Engineers Comments Regarding Surface Water Drainage

Application Reference:	WA/11/25/DOC	Reviewer Reference:	ADC/PC
Planning Officer:	Hebe Smith	Date of Review:	12/09/2025
Site Name:	Snetterton West Walberton Lane Walberton BN18 0QS		
Application Description:	Approval of details reserved by condition imposed under WA/46/22/HH relating to condition 3-surface water drainage.		
Assessment Number:	1 of 2

Application Reference: WA/11/25/DOC Site Name: Snetterton West Walberton Lane Walberton BN18 0QS	Initial Issue Date: 07/10/2024 Issue Date: 12/09/2025 Reviewer Reference: ADC/PC
---	---

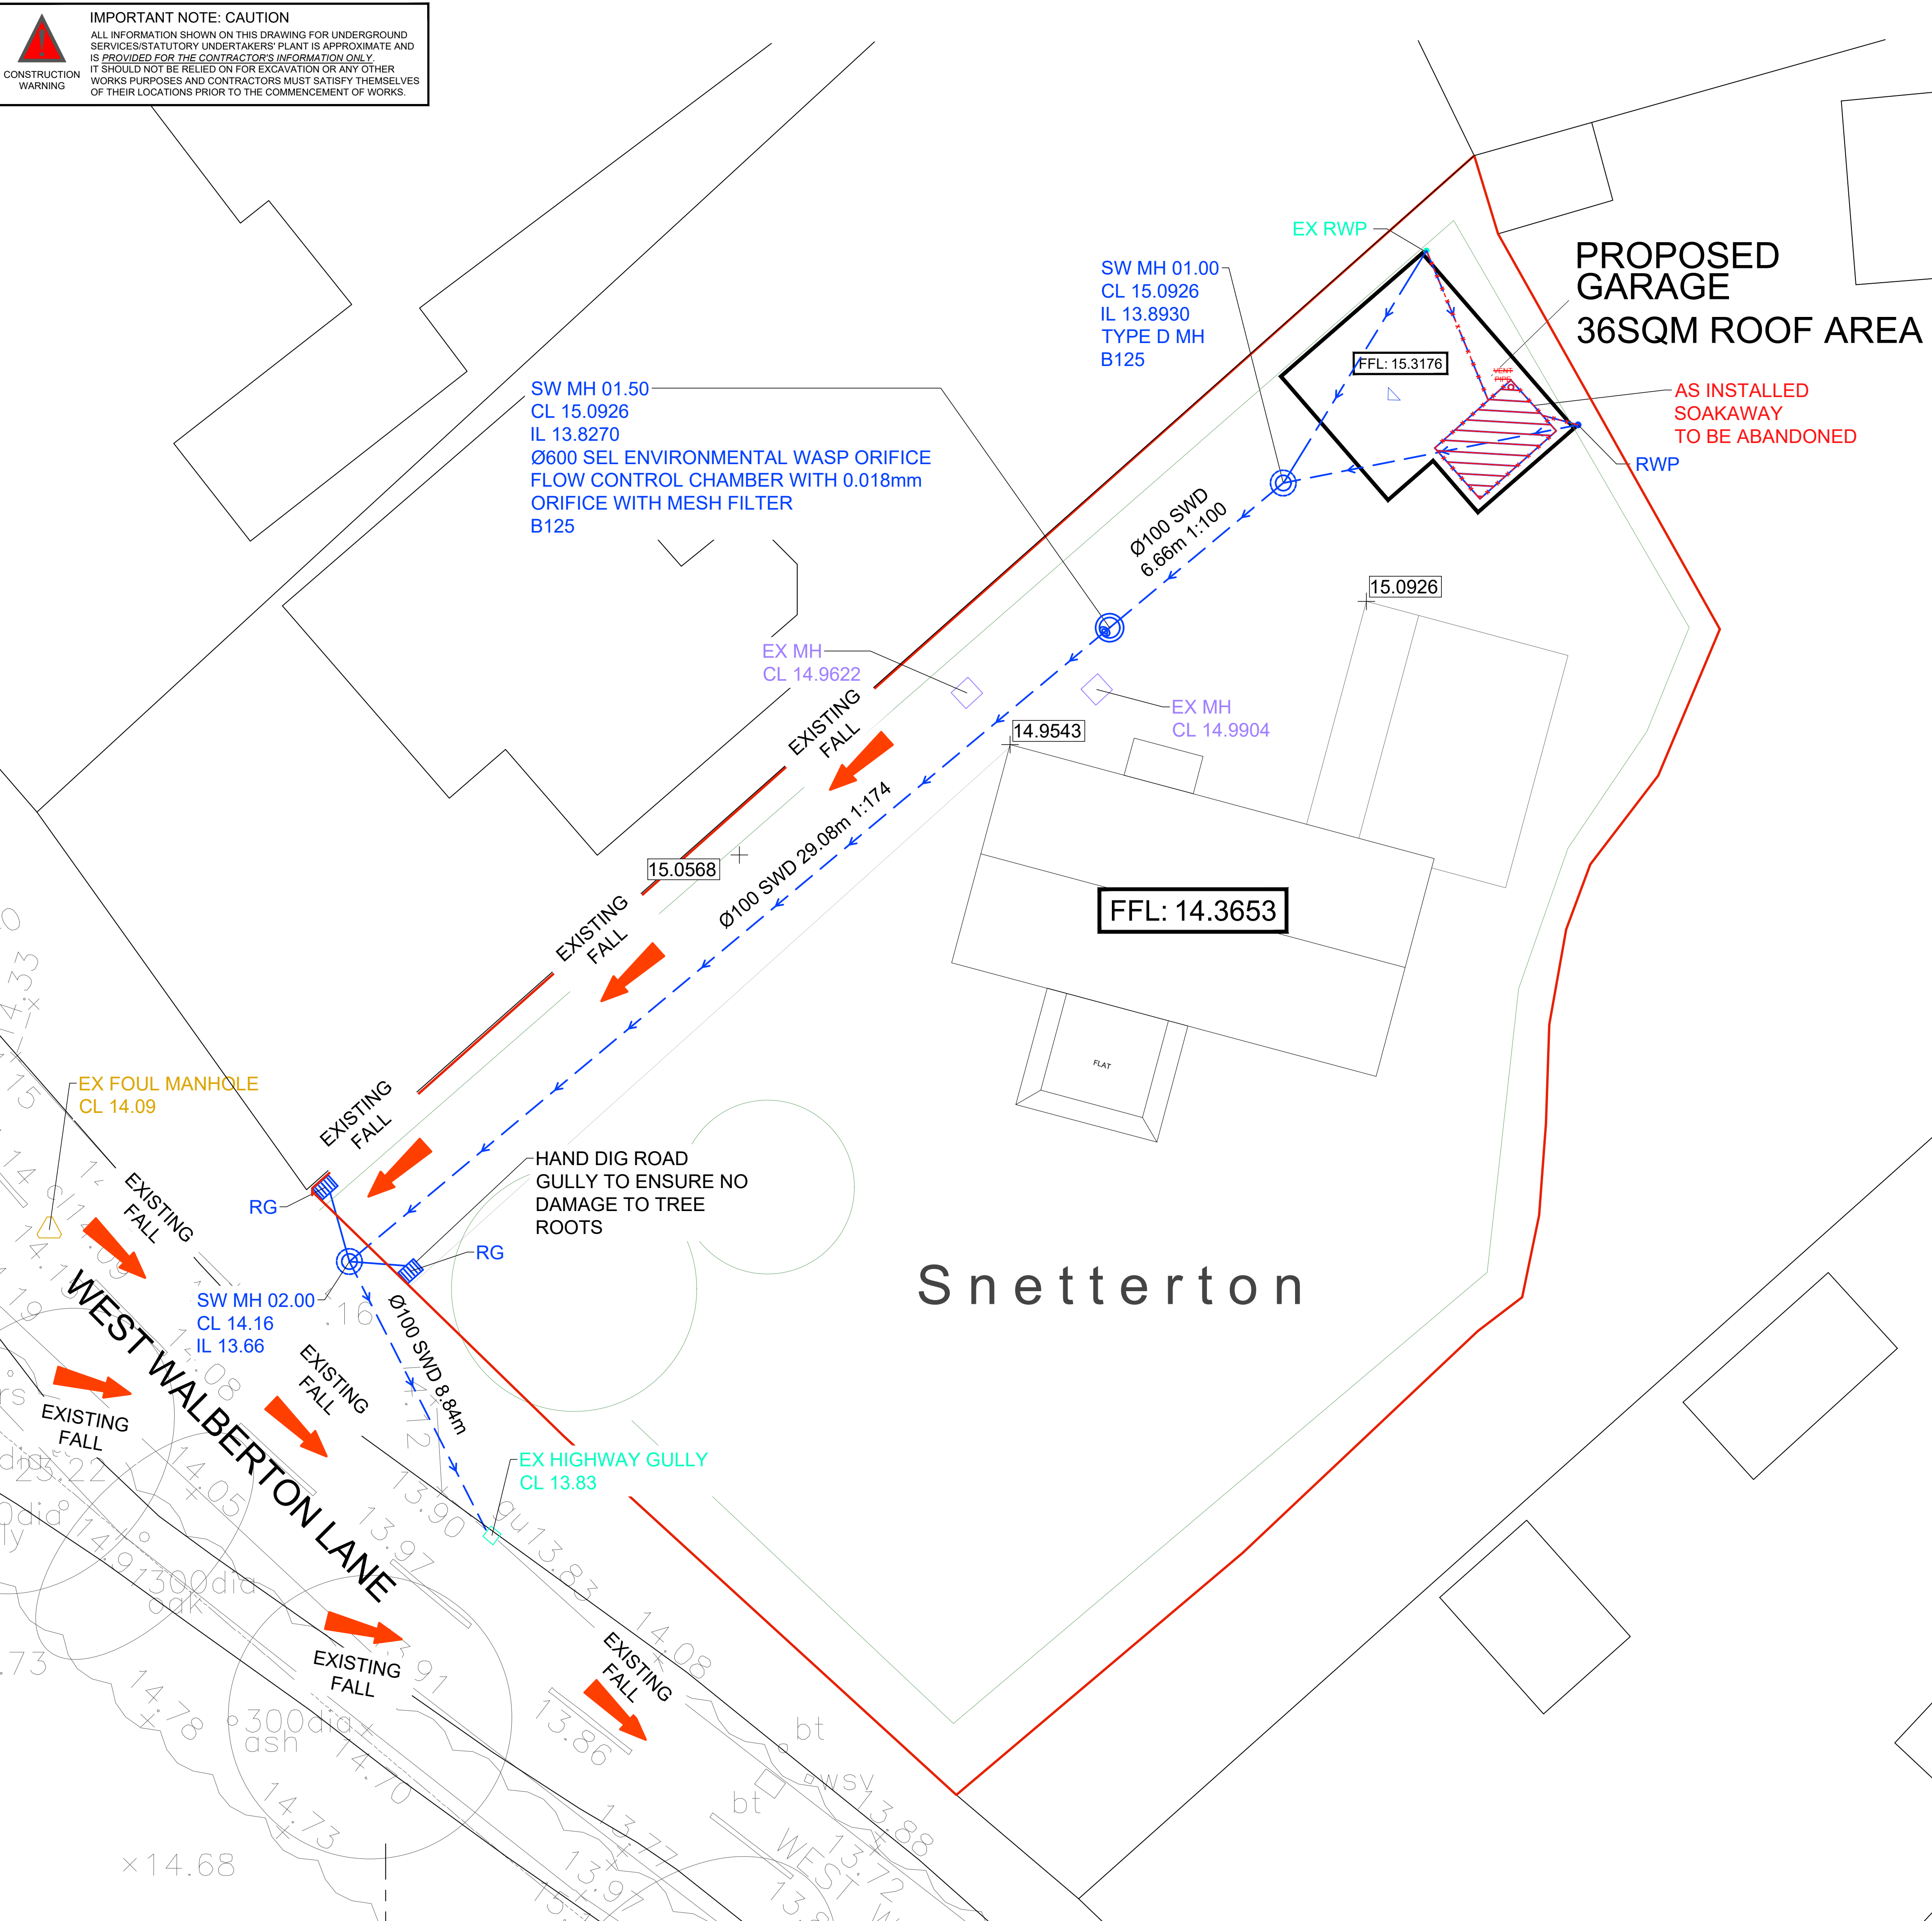
The hierarchy for sustainable drainage.	The proposed discharge method must accord with the SuDS hierarchy as given below. Evidence must be supplied to justify the proposed discharge method. 1. Rainwater reuse where possible. 2. Complete discharge into the ground (infiltration). 3. Hybrid infiltration and restricted discharge to an appropriate water body or surface water sewer. 4. Restricted discharge to an appropriate water body. 5. Restricted discharge to a surface water sewer. 6. Restricted discharge to a combined sewer. A water body may be defined as a river, watercourse, ditch, culverted watercourse, reservoir, wetland or the sea.	Sufficient

Engineers cannot support any proposed connection of surface water to the foul sewer.	
Calculations	Calculations for pre-development run off rates must be based upon the positively drained area only. Proposed discharge rates must not increase flood risk on site or elsewhere. Discharge rates must be restricted to QBAR or 2 l/s/ha, depending on whichever is higher.	Sufficient
	Designs must be based on the most recently available rainfall data at the time of conditions being applied. <u>FSR rainfall data will not be accepted.</u> FEH rainfall data is based upon more recent records and continues to be updated.	Compliant
	Designs must use the correct climate change allowances at the time of determination of the outline or full planning application. CV values for all events must be set to 1. This includes summer, winter, design, and simulation events. The correct allowance for urban creep must be applied. Additional storage must be set to zero unless it can be evidenced where this is provided. Infiltration half-drain times must be less than 24 hours. Infiltration design rates must be applied to the sides of soakaways, or to the base of infiltration blankets. Design rates must not be applied to both the base and sides of infiltration structures. A surcharged outfall must be modelled.	Insufficient – surcharged outfall implications to be considered further.

8.	Please submit calculations to support the design – refer to the attached checklist for requirements.	Thank you, but the design is still allowing infiltration, and the overflow is unrestricted. Best practice design rules are unchecked. The garage is	The pipework between MH SW 02.00 and the existing road gully needs to be included in the calculations. CV values for all events must be set to 1. This includes summer, winter, design, and simulation events. Urban creep needs to be applied;	Pipework between MH SW 02.00 and Existing Highway Road gully added CV set as 1 for winter and summer 10% Urban Creep has been applied FEH 22 used, excel attached	Noted. It is unclear how the surcharged outfall has been modelled. The surcharged outfall is normally specified as such in the simulation settings. In the calculations, an additional flow control has been added to SW MH 02.00?? Please explain/adjust.	A 1mm orifice was put on the EX HW RG note to represent no flow through the gully due to it silting up. Revised calculations attached with a surcharge outfall using the Hydrograph section of Flow	Two sets of calculations have been provided, one with a surcharged outfall and the other not. The set without a surcharged outfall should be labelled as such (both currently labelled as surcharged). Following the redesign of the pipework/chamber

claimed to be on existing driveway, this is not shown on the previous block plans for the site. The previous garage was in a different location. The proposed discharge rate must be as close to greenfield (QBAR for all events) as possible without risking blockage	ie. 10% increase in impermeable area. The use of FSR rainfall data is not acceptable and FEH must be used. Submit the FEH 22 point data files for this parcel, in accordance with clause 5.1.7 of the FEH Web Service terms of use (https://fehweb.ceh.ac.uk/Home/Terms). These must be submitted directly to land.drainage@arun.gov.uk rather than to the planning portal (via the planning officer), this is to ensure that the data remains confidential in accordance with those terms. Correct climate change allowances to be used ie. 1/100 year event 45% and 40% for all other storms. A surcharged outfall must be modelled ie. assume the cover level of the existing road gully	1:100+45%, 1:30+40% and 1:1+40% modelled. We have provided calculations showing 0 discharge from MH 02.00. If the Highway drainage was to become surcharged water from the site would surcharged from the two gullies on to the highway	Thus the connection to the assumed 150mm diameter highway drain gully (to be rebuilt as per item no.5) will need to achieve a connection invert level of 13.330, unless you propose to lay a 150mm diameter pipe as opposed to a 100mm diameter pipe. Adjust calculations to suit new level.	arrangements downstream of SW MH 02.00 it is necessary to model the networked system up to the replacement catchpit gully in West Walberton Lane – please revise accordingly. The surcharge level/depth should reflect the cover level at this location ie. 13.830. Although the current modelling needs to be revised to reflect the above, it is noted that there is currently above ground flooding on both the 1 in 30 and 1 in 100 year events. Flooding on a 1 in 30 event is not acceptable and must be retained below ground. Any flooding resulting from a 1 in 100 year event must be retained on site. Based upon the modelling and topography, this is not being achieved, as excess water would flow onto West Walberton Lane. It is clear that the applicant needs to reconsider their design to ensure that the 1 in 30 year event is stored below ground and the 1 in 100 year event does not flow off site.

16.			The gradient of pipe length SWMH 01.50 to 02.00 is slacker than the minimum permissible gradient for a 100mm pipe. A minimum 1 in 100 gradient or steeper must be achieved.	Gradient amended to 1:100	Noted. Comment closed.	CLOSED

17.			The proposed surface water drain is shown running between two existing manholes adjacent the house. Assuming these relate to existing foul drainage, please provide details ie. pipework configuration, diameters, invert levels). This is to ensure that the proposed surface water drainage does not clash with existing pipework, in terms of levels.	Inverts of foul drainage added, the proposed surface water run is deep than the existing foul drainage so there is no clash	Noted. Comment closed.	CLOSED

19.			The proposal for two road gullies at the end of the driveway before it meets West Walberton Lane is noted. Whilst it is appreciated that the surface water runoff from the existing driveway discharges onto the public road, WSCC will still need to agree this arrangement. Please provide evidence of this approval.	WSCC have approved the connection and arrangement of the surface water drainage, refer to email	Noted but see comment no.5. Comment closed.	CLOSED

20.			Proposed manhole SW MH 02.00 may be located in public highway. Please provide evidence that this is acceptable to WSCC.	This has been moved to the end of the drive	Noted but see comment no.5. Comment closed.	CLOSED

21.			The proposed road gully directly east of MH SW 02.00 is connecting against the flow in the pipeline and will need to be reconfigured.	This has been resolved with a standard 450 dia radius on the outlet pipe so that the PPIC can be oriented to have the gullies coming in the side	Noted but see comment no.5. Comment closed.	CLOSED

22.			Specify proposed discharge rate on drainage layout plan.	Added to plan	Noted. Comment closed.	CLOSED	
23.			Flows to be restricted to 0.5 l/s for all storm events.	Noted, maximum rate for the 1:100+45% storm is 0.5l/s	Noted. Comment closed.	CLOSED

24.					Upstream of SW MH 01.00, where there are rodding eye arrangements. Please either replace this arrangement with new manholes at the points of redirection or show the rodding eye arrangement more clearly ie. indicate the pipes downstream of the RWP's connecting just downstream of the rodding points via oblique 45 degree junctions.	RE moved further away from point of connection	Noted. Comment closed.
-----	--	--	--	--	--	---	------------------------
